Project: Mars Data Centre – SSD-82052708 – 12 Mars Road, Lane Cove West

Subject: Objection to Proposed Data Centre Development in Lane Cove West

5 May 2026

DRAWING TITLE
SECTIONS SHEET 1 OF 2

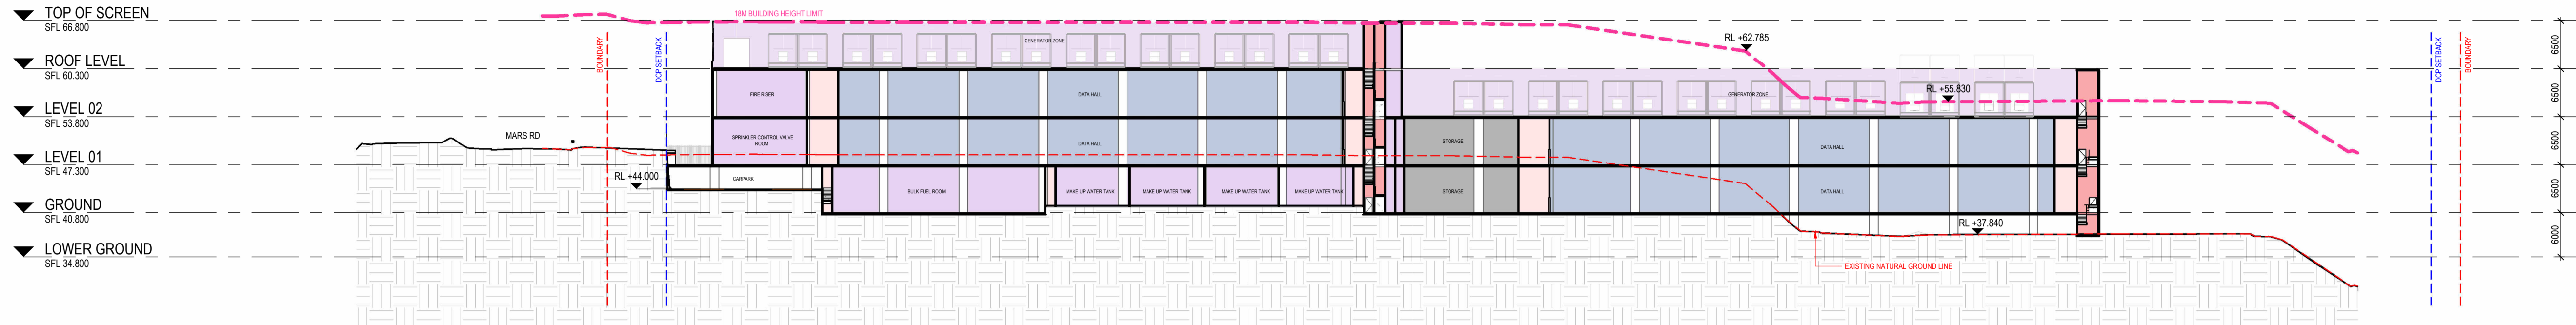
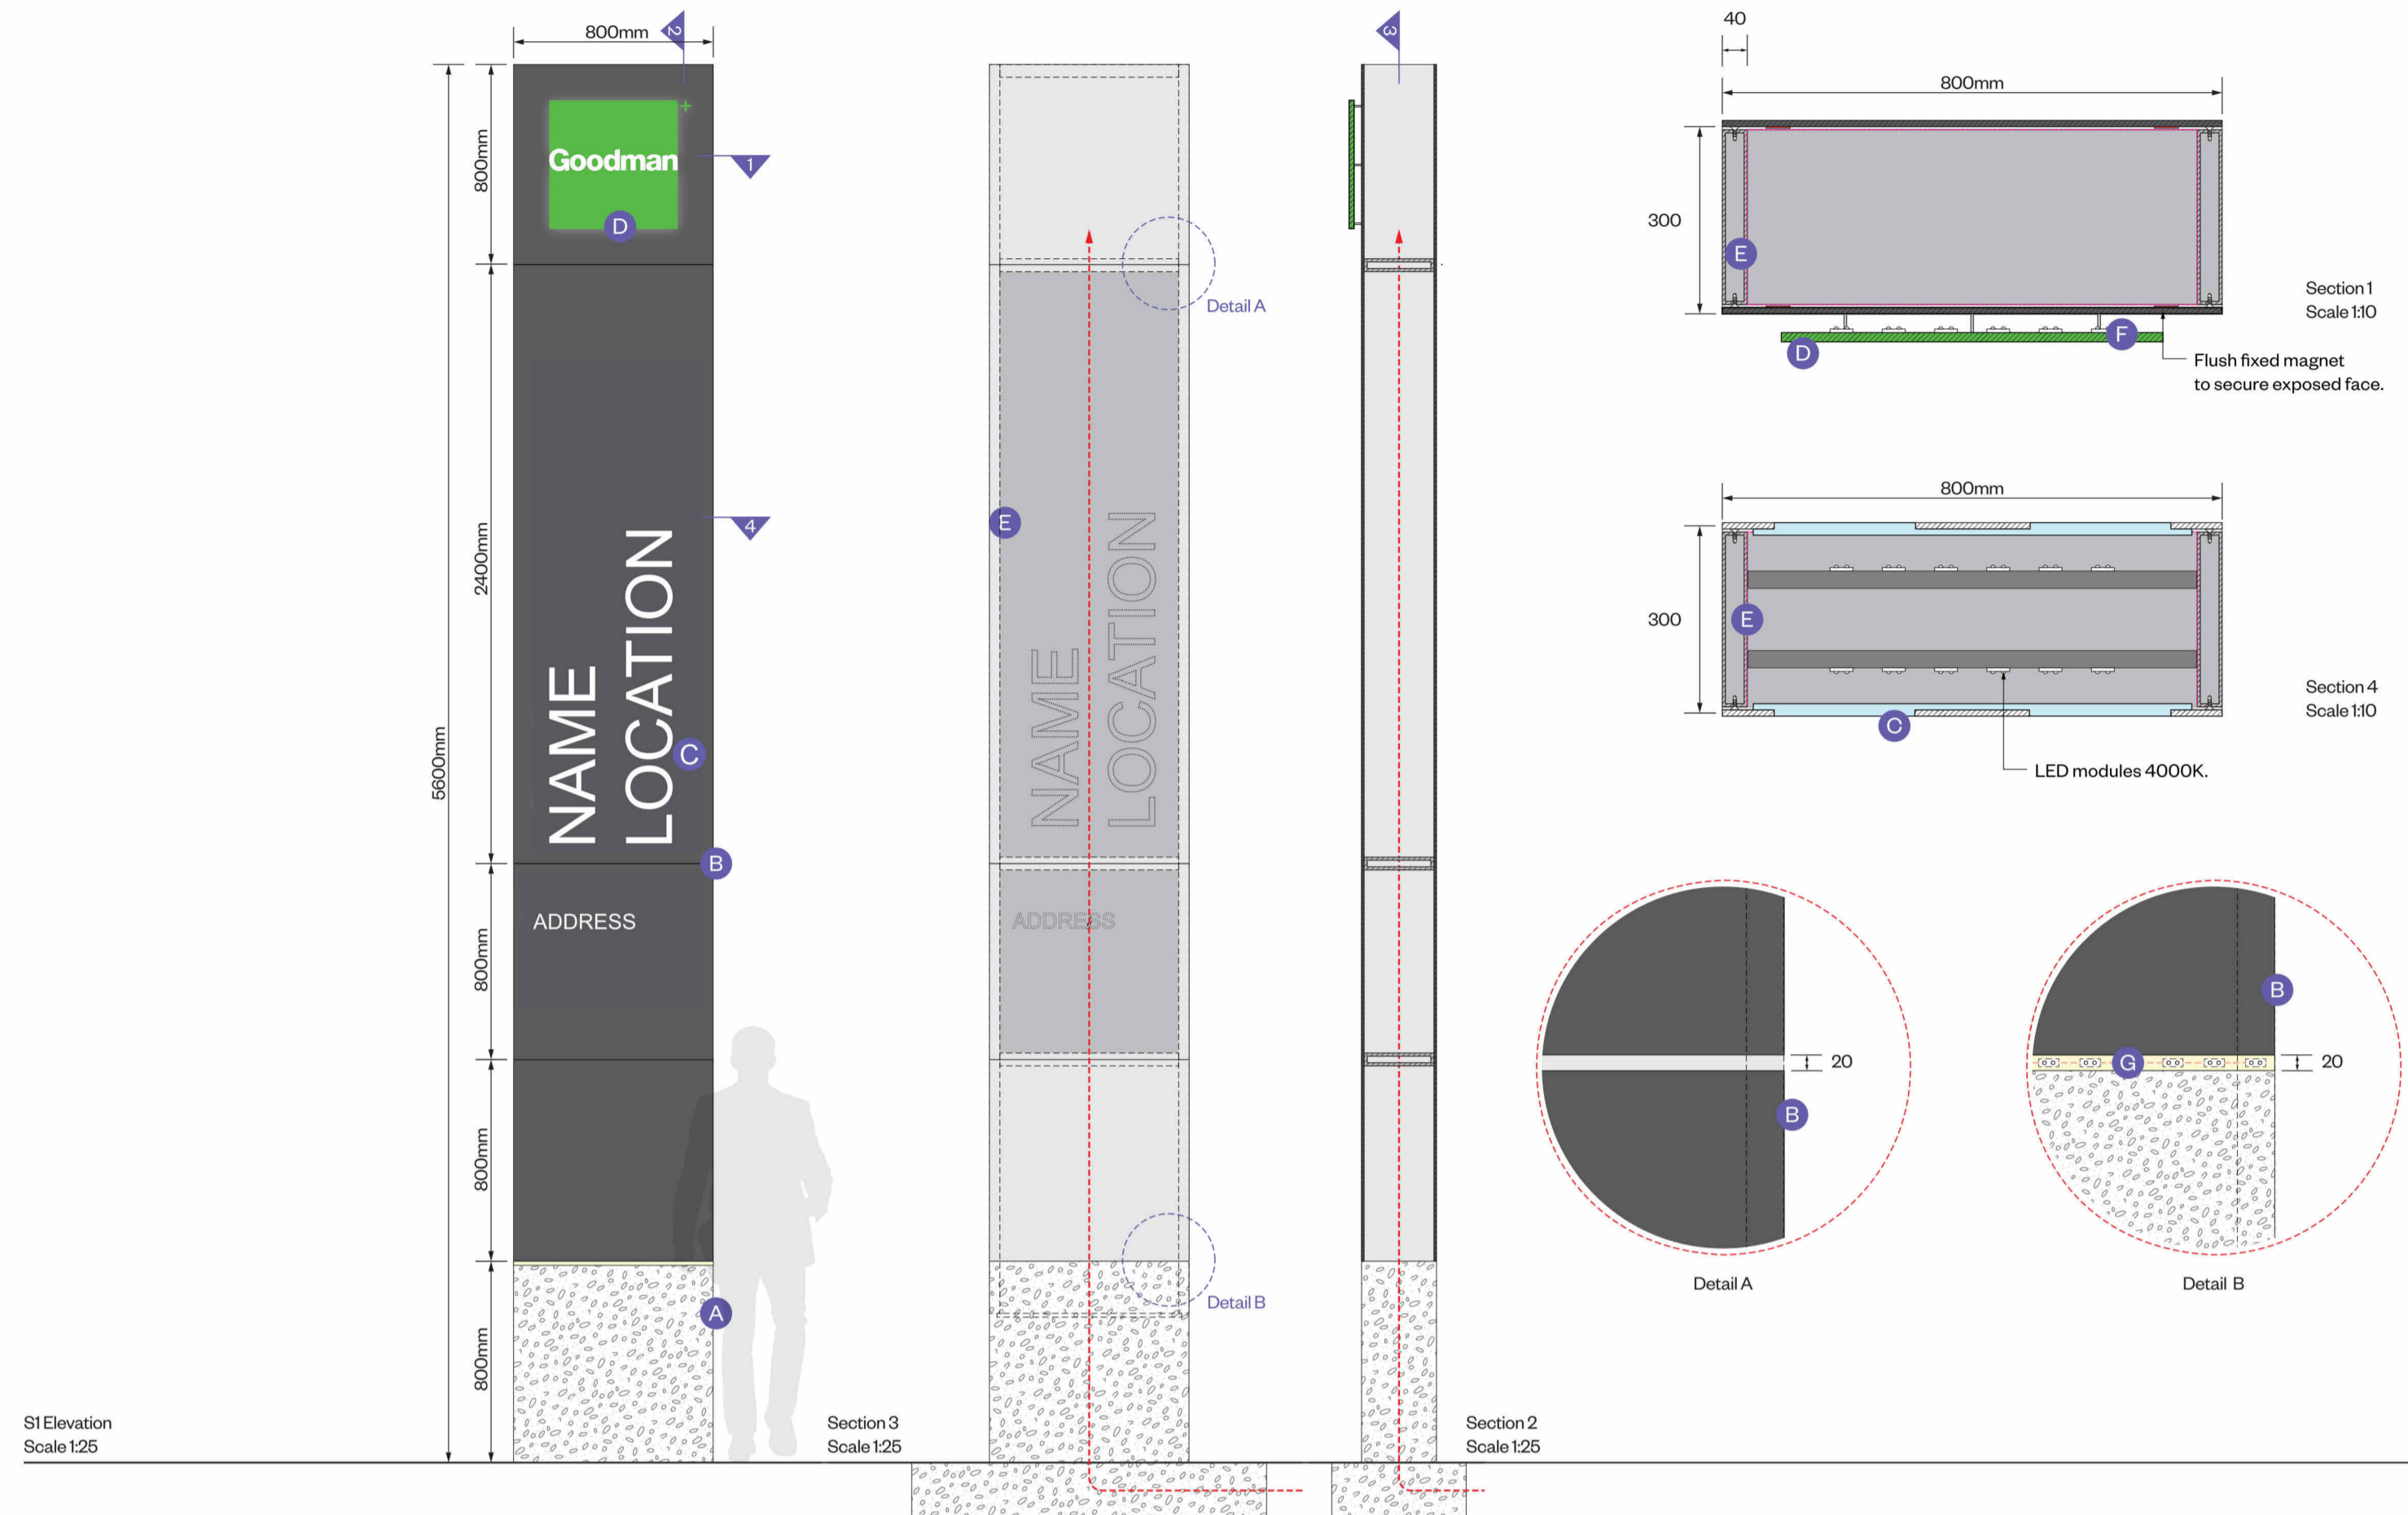
The Visual Impact Assessment prepared by Urbis dated December 2025 has selected locations where the view of the building is obscured by trees in the foreground, and omits locations where the local community is most likely to view the development, particularly where the bulk is the greatest. For example, Lloyd Rees Drive is the only vehicular access to Blackman Park. This park is an important, highly utilised and much-loved community sporting a recreation facility. Both the ground floor and the top of the building will be visible from Lloyd Rees Drive. As illustrated in the markup of the building floorplan (below) and using data from the Site Survey prepared by LTS, **when viewed from Lloyd Rees Drive the visible building height will be 32.925m, almost double the allowable building height of 18m under the DCP. This is further illustrated by indicating the approximate location of Lloyd Rees Drive on the section (below).**

Mark up op architectural drawing illustrating that the building height perceived from Lloyd Rees Drive is 32.925m

Mark up of architectural drawing illustrating that the building height perceived from Lloyd Rees Drive is 32.5m

Whilst this 57.2% breach to the development standard is outrageous on face value, it also significantly understates the perception of the bulk and scale of the building at adjacent sensitive community and residential uses. The site falls away towards east and south where the sensitive uses are located. Therefore, the perception of overbearing height and scale is amplified at the sensitive uses by virtue of these being located downhill from the development.
